Condition 11- Surface Water Drainage Design

Application No: CM/11/21/DOC

Site Address: Scyld Horsemere Green Lane Climping BN17 5QZ

Description of Works: Approval of details reserved by condition imposed under CM/21/19/PL relating to conditions 11-surface water drainage scheme, 12-discharge of flows to water courses or for the culverting, diversion, infilling or obstruction of any water course on or adjacent to site & 13-maintenance and management of surface water drainage system.

DETAIL 1: TYPICAL SECTION SHOWING NEW ENTRANCE AND
EXISTING HIGHWAY WITH NEW CULVERT
SCALE 1: 20

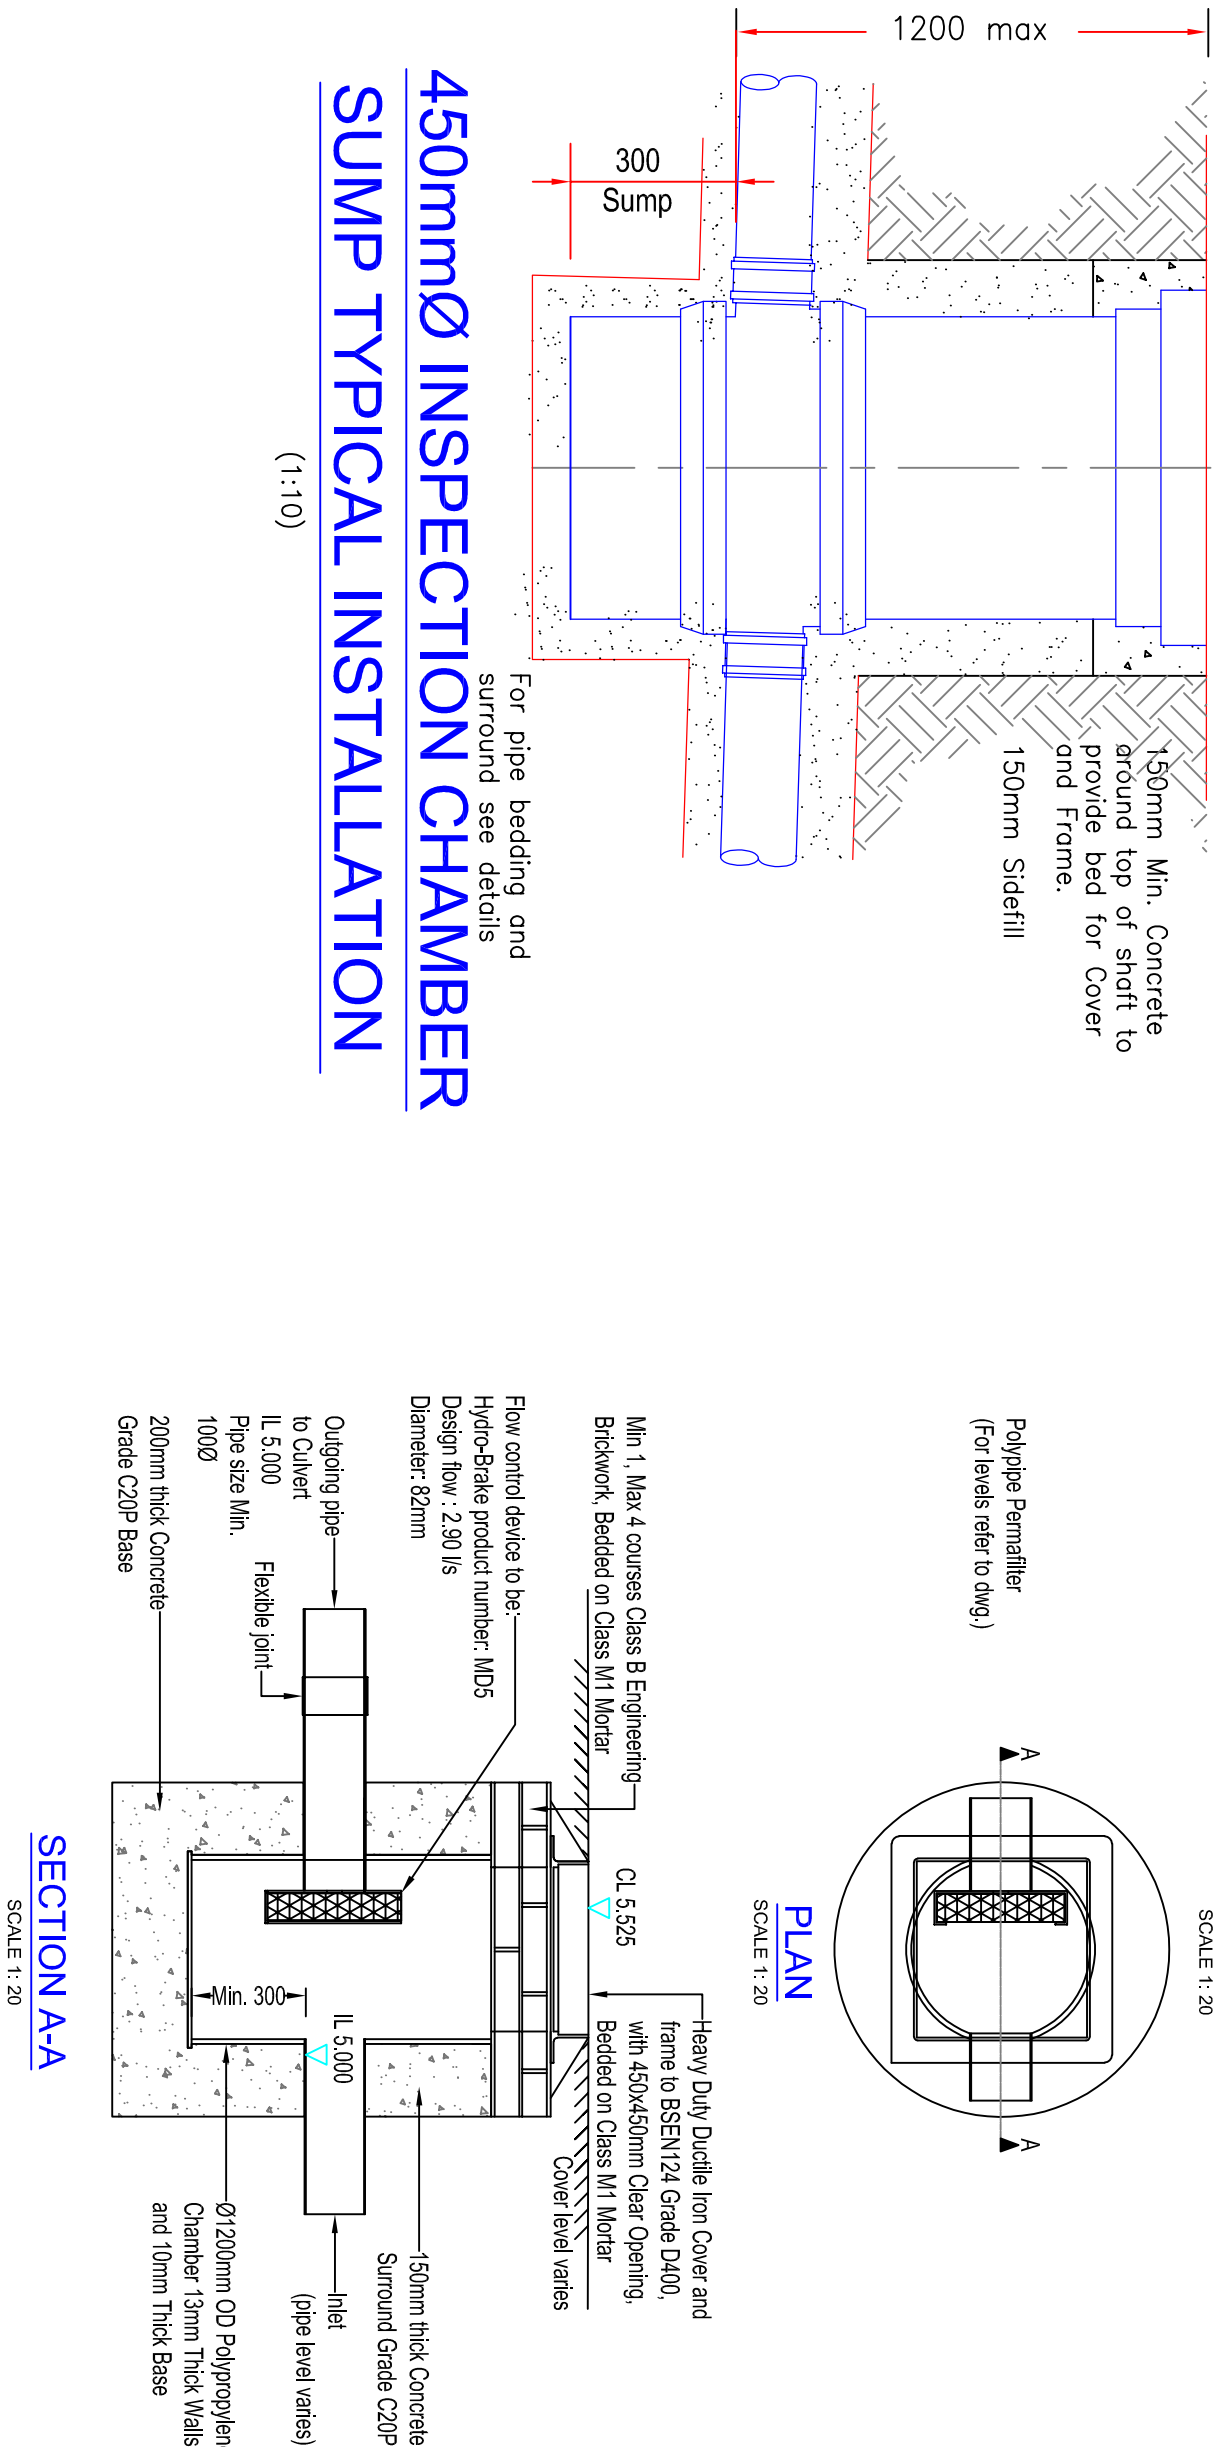
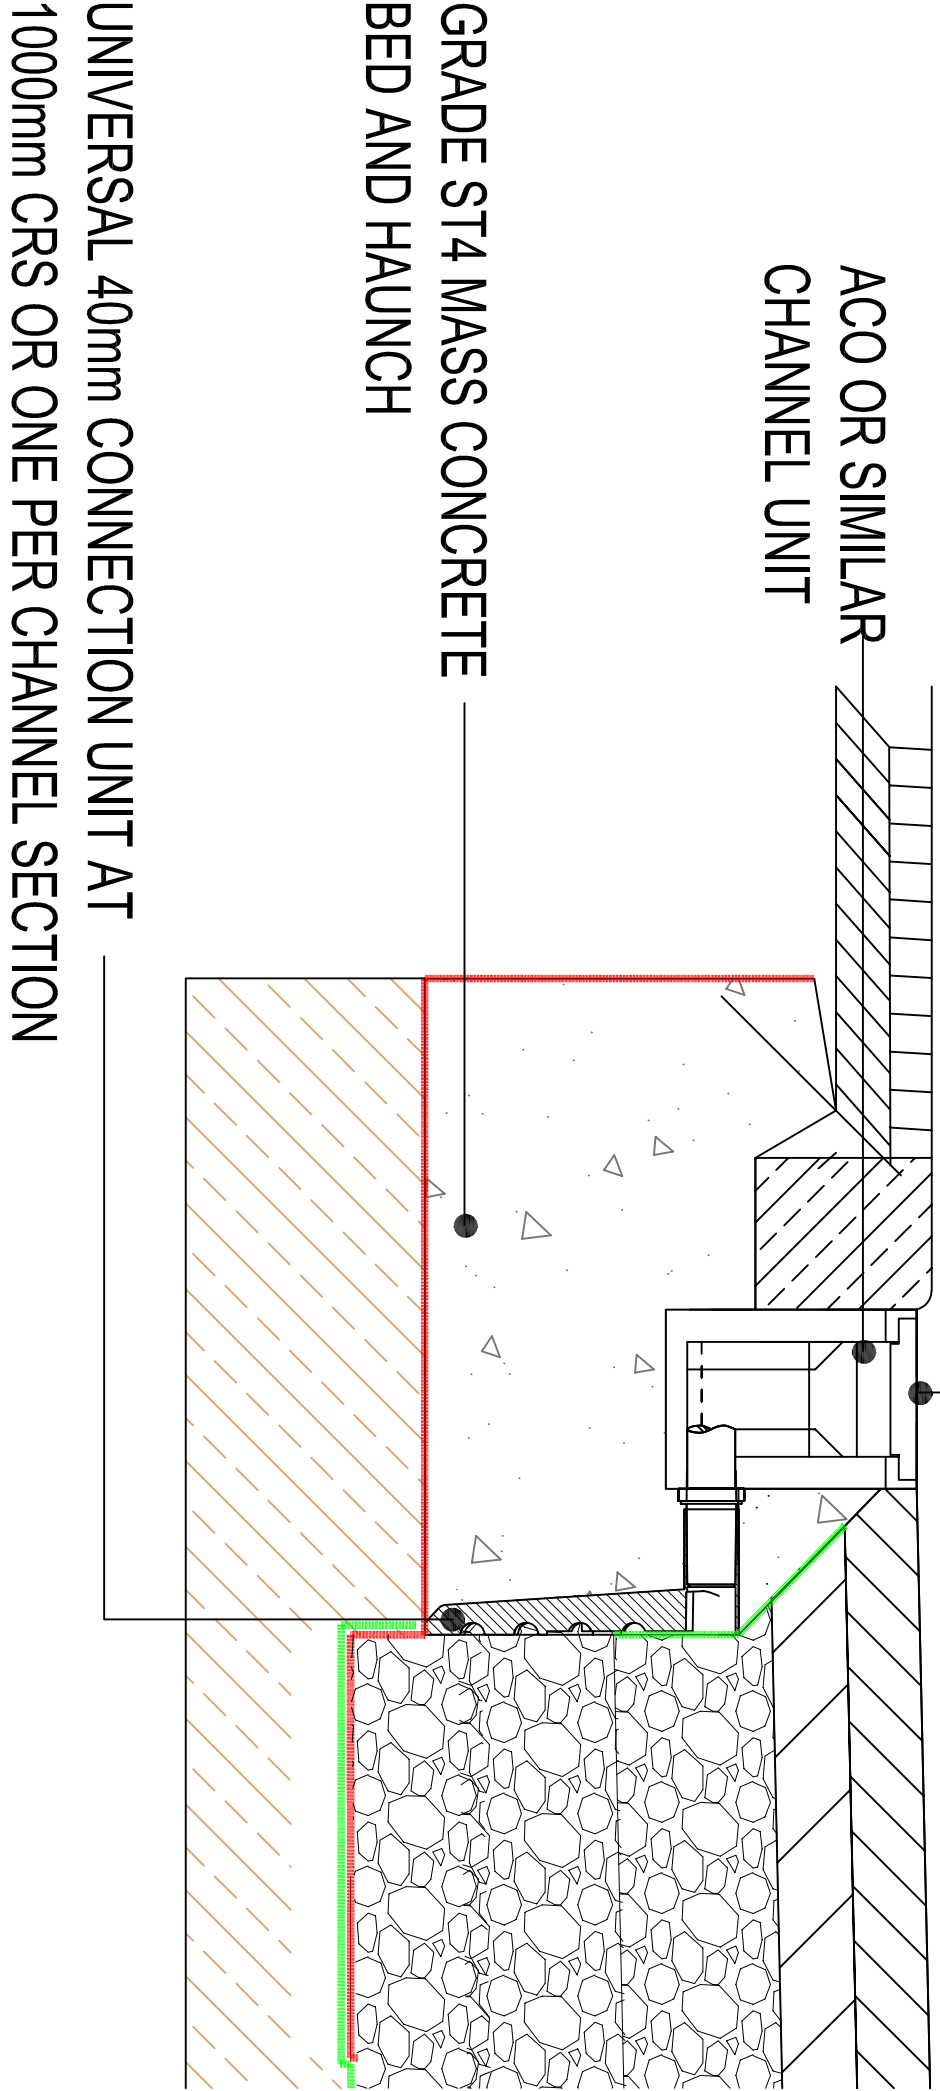
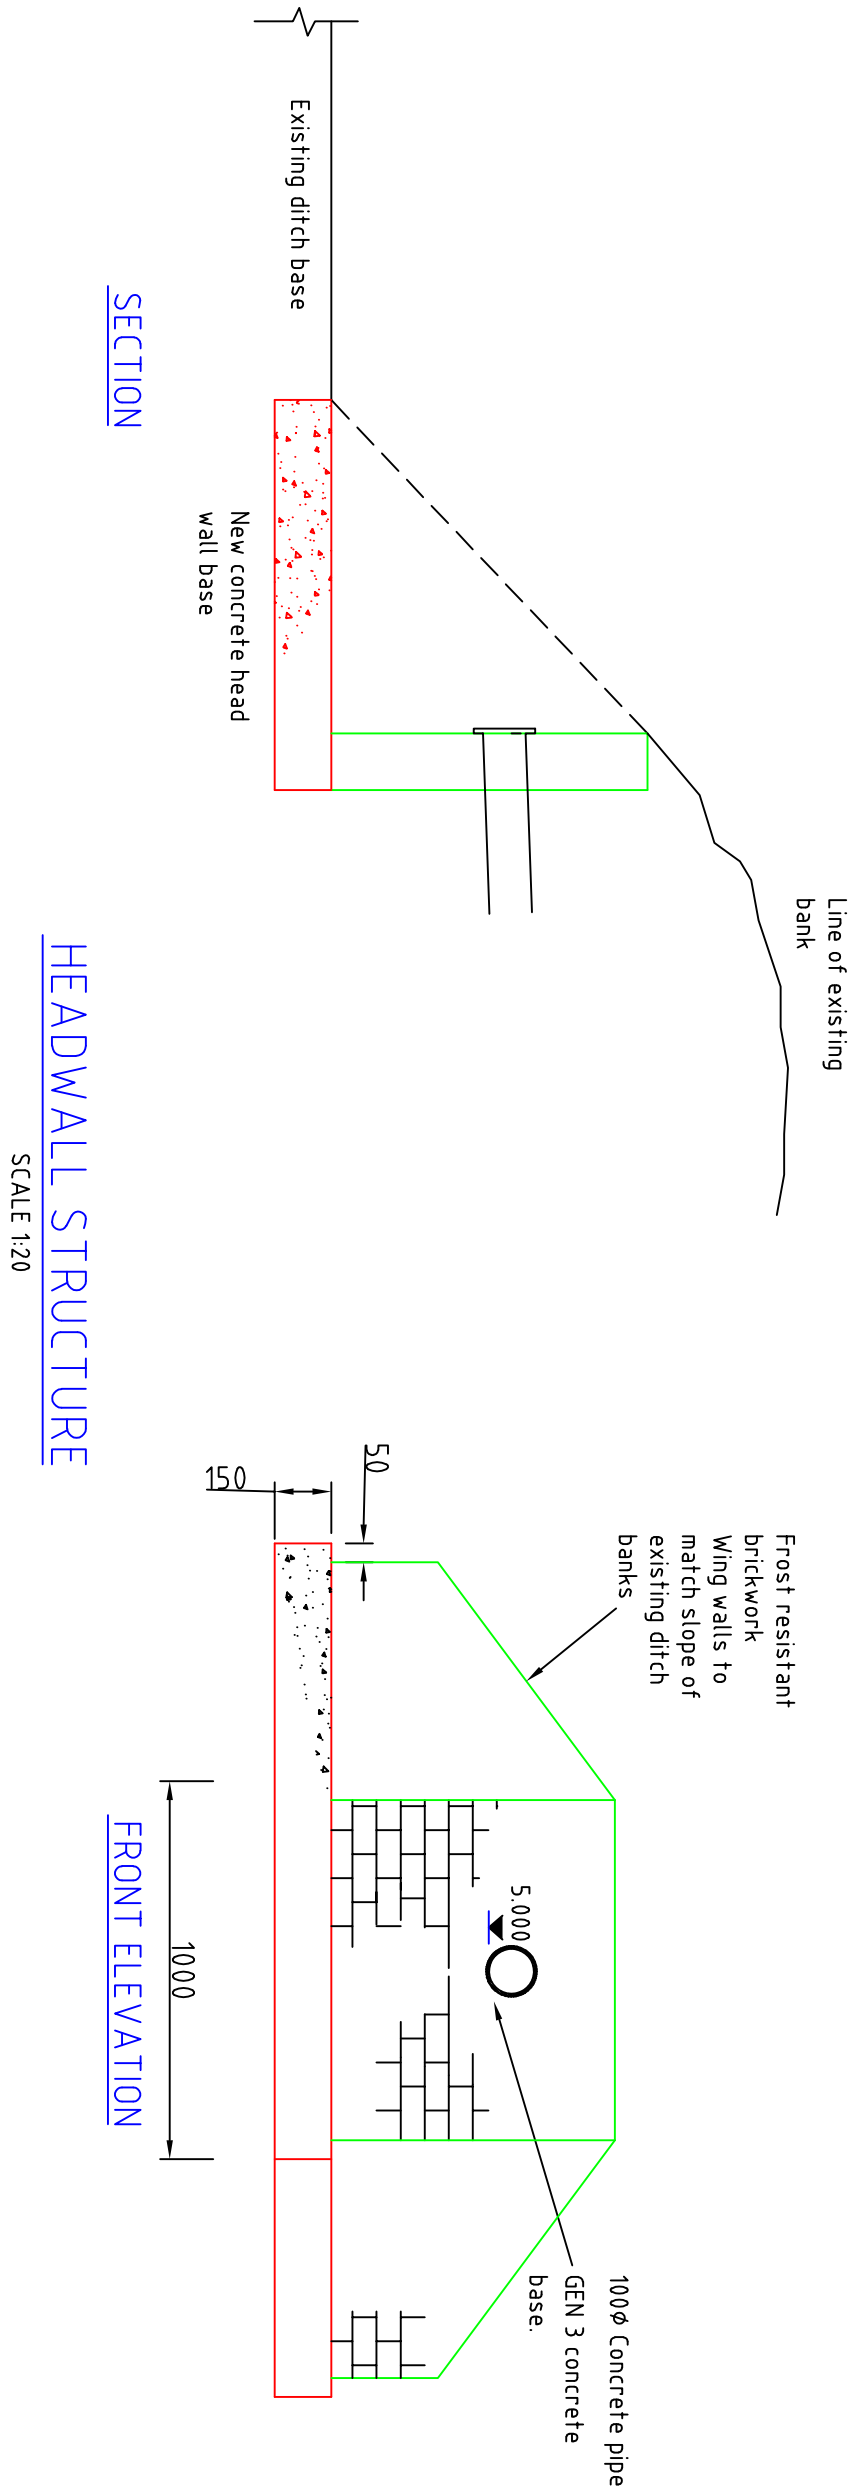
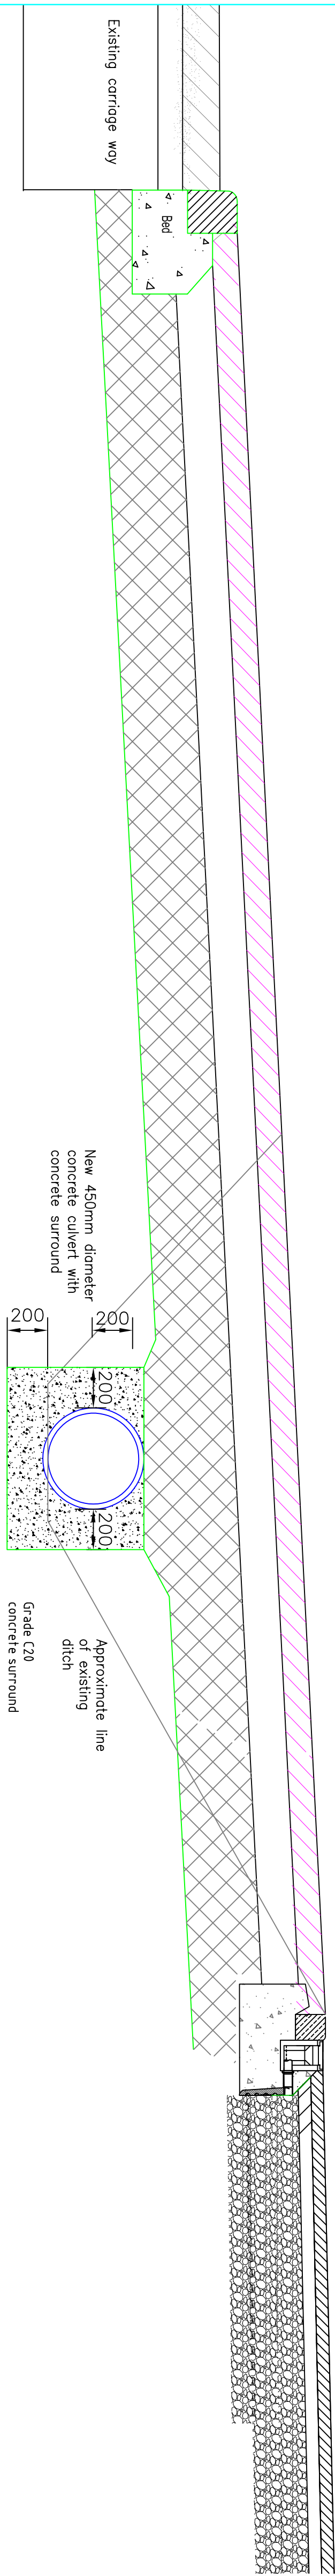
3. The long section on the drainage details sheet 1 refers to a hydrobrake with a restriction of 2.0l/s, which conflicts with the calculations, other details and layout (although addressing point 1 will affect these).

DRAINAGE GA

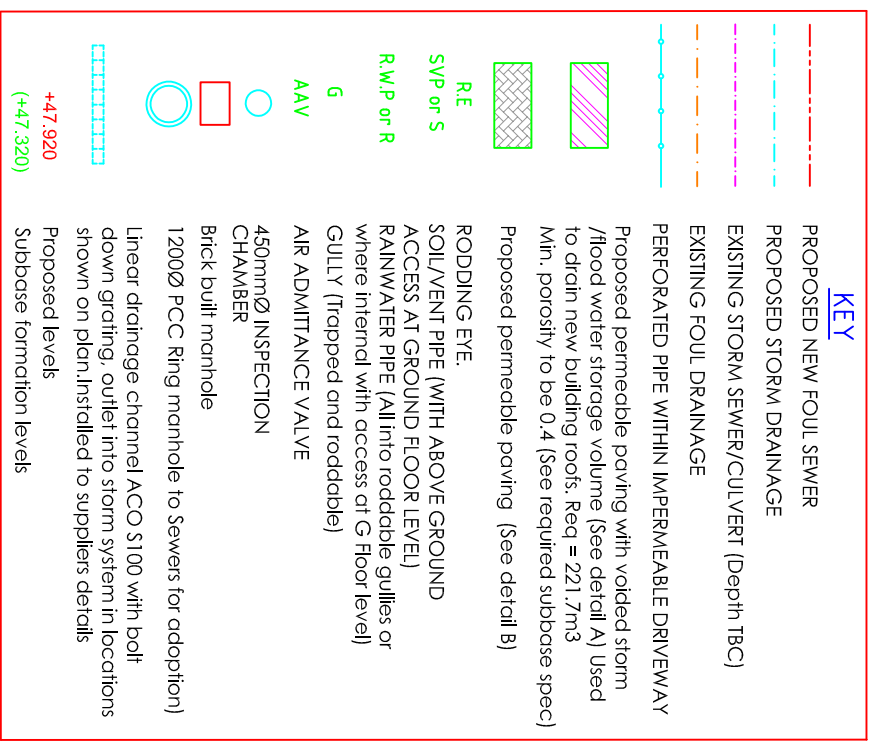
4. Please detail finish and formation levels of permeable paving on plan.
5. Please make the permeable paving construction details clearer. I.e. please provide one which clearly details the driveway construction, and one which details the road construction. Both must clearly state minimum required sub-base depth.

6. Please detail all pipe diameters and falls on plan.
7. No connections are shown to/ from the permeable car park areas.
8. Please provide site specific construction detail drawings of the proposed headwall, this should include a plan and full cross section through the ditch. All headwall drawings should indicate existing bed level, and top of bank level.

DETAIL 1: TYPICAL SECTION SHOWING NEW ENTRANCE AND EXISTING HIGHWAY WITH NEW CULVERT

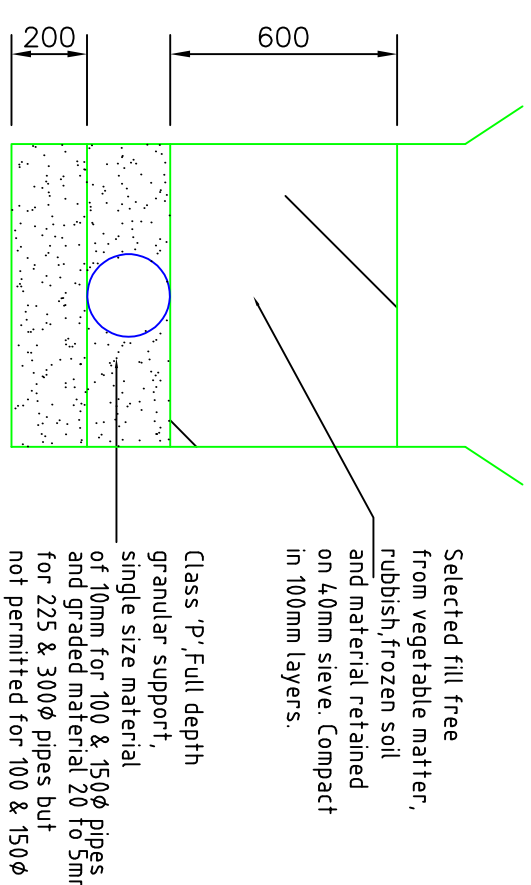
1. Please supply further details of the proposed culvert, i.e. diameter, invert level, and construction details- including headwalls.
2. It is stated on the plans that the culverting has been agreed, we do not believe this to be the case. Please supply evidence that an application for land drainage consent has been made for both the proposed culverting and outfall headwall.
